**SUBMISSION TO THE DEPARTMENT OF PLANNING AND INFRASTRUCTURE ON THE PROPOSED
NORTH WEST RAIL LINK (NWRL)**

Application Number: SSI-5100

Figure 6.11 Cheltenham Services Facility light vehicle access and egress

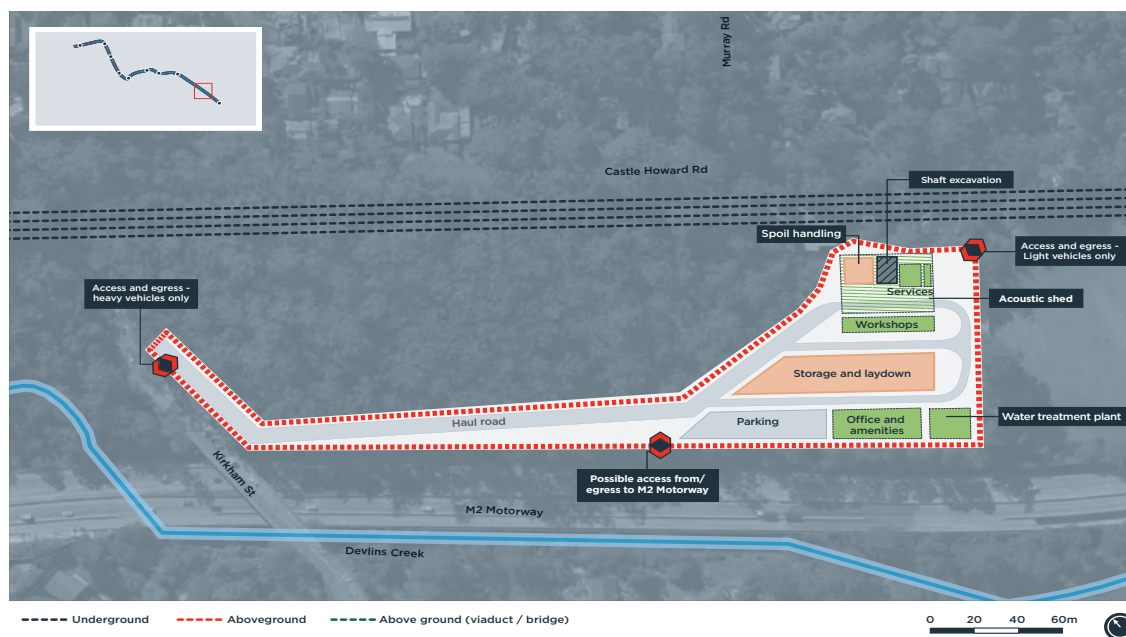
1. The option to construct a new two lane paved road through the Castle Howard Conservation Reserve to Kirkham Street (or Castle Howard Road) near the bridge over the M2 to allow trucks to remove spoil during construction and light vehicle access during operation of the facility will permanently destroy valuable Blackbutt Gully forest.

5. Should the roadway be built, the local streets (Kirkham Street, Castle Howard Road, Murray Farm Road and the bridge over the M2) are narrow, winding and congested and would not be suitable for trucks and, in the event of an emergency, large numbers of emergency vehicles.
